FW: An Coimisiún Pleanála Case Reference: ABP-319866-24 (OA29N.319866)

An Coimisiún Pleanála Case Reference: ABP-319866-24 (OA29N.319866)

Observations on the Significant Further Information

North Irish Sea Array (NISA) Offshore Wind Farm

VP24 (View 1) Baseline Photo and Wireline  
Amenity Area Skerries (Fingal),  
Co. Dublin

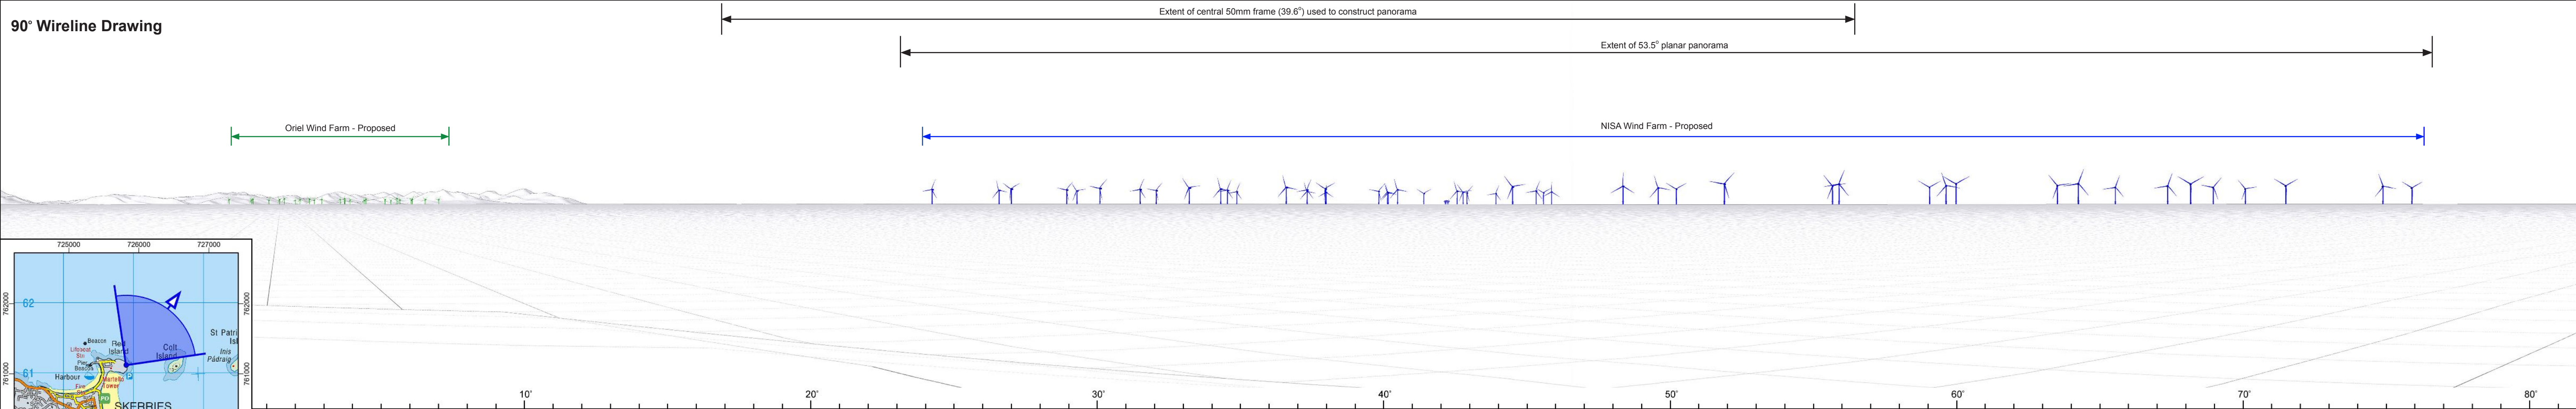
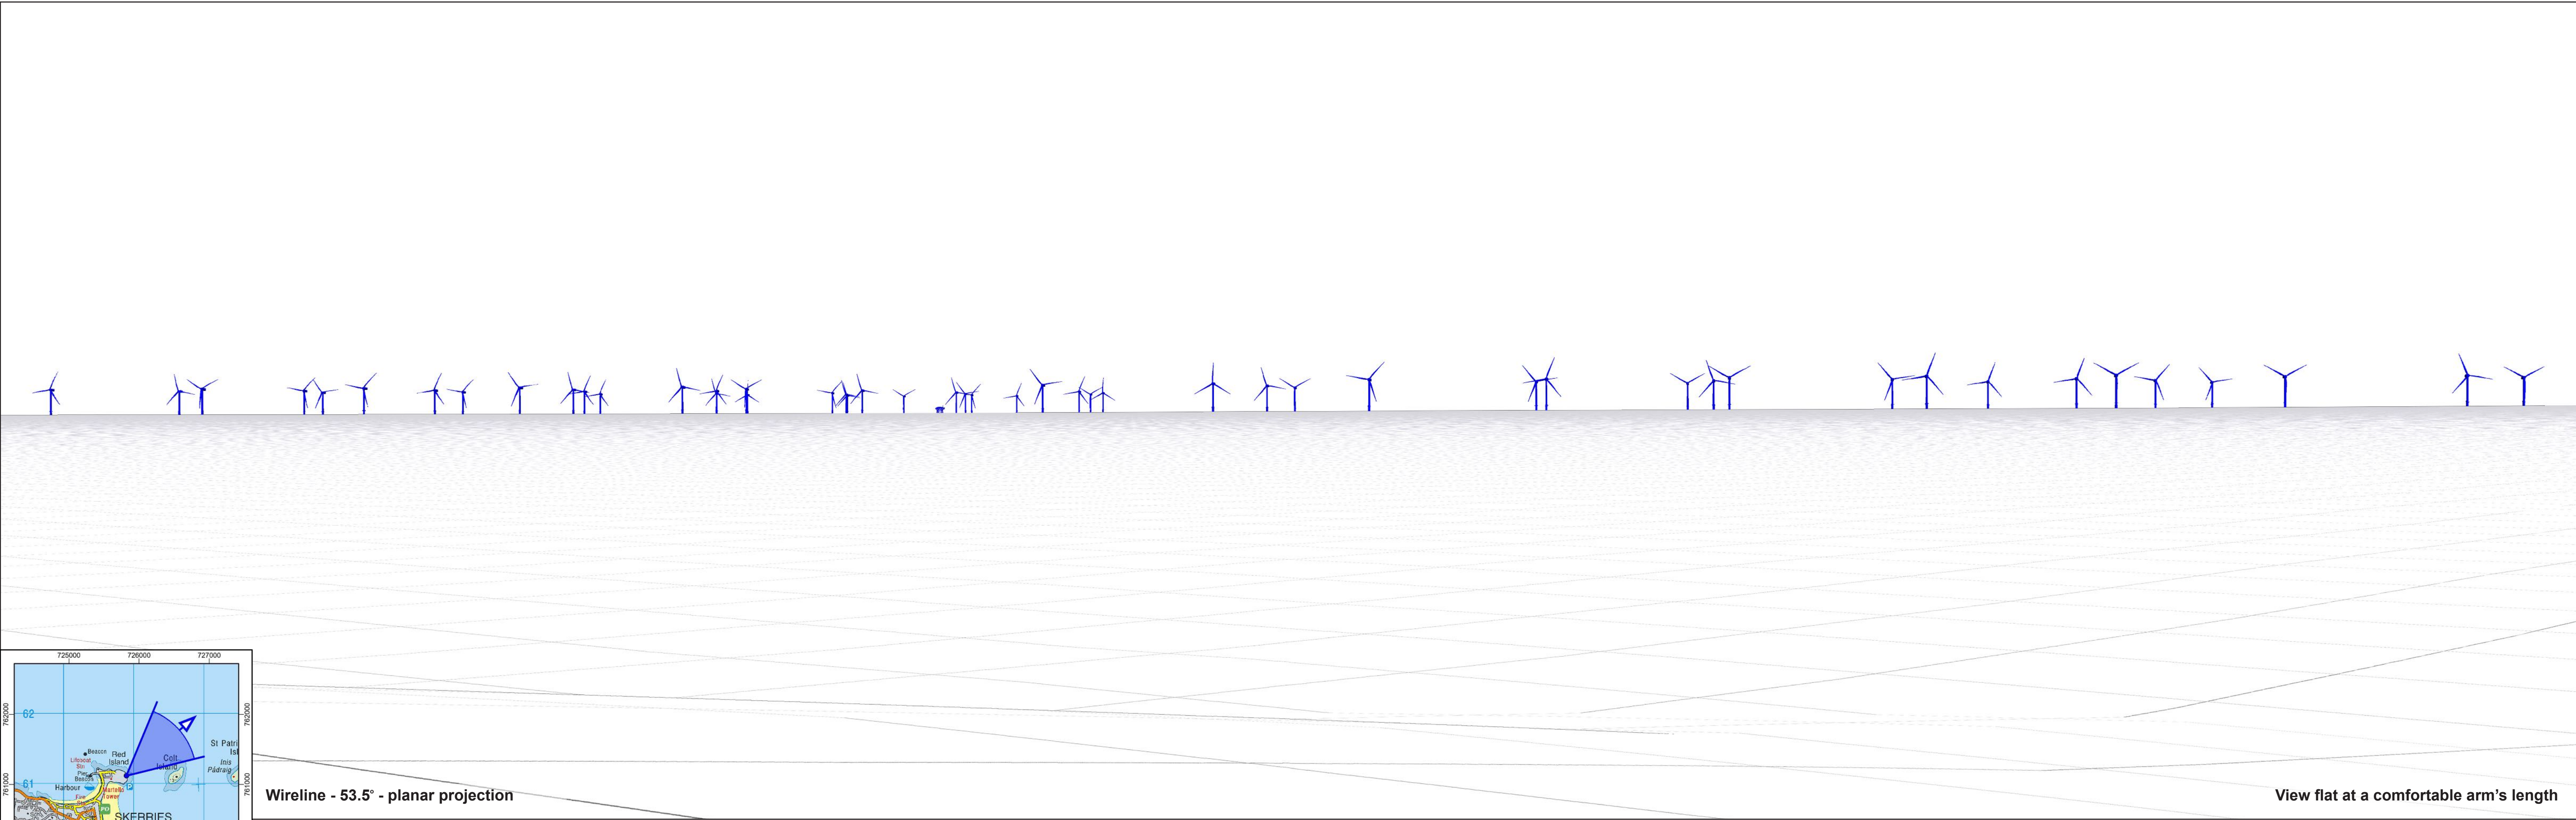
(5) The applicant's own assessment finds major-moderate visual effects at Skerries, Loughshinny and Ardgillan. The applicant calls these effects "not significant" only because of a threshold it set itself; under the UK research and practice it relies on (including the White Consultants² studies for the UK and Welsh governments), effects of this level are significant. Turbines of up to 316 m are normally placed around 30 km or more from a sensitive coast, not 12.4 km. And the public had no meaningful opportunity to influence the scale or layout of the project.
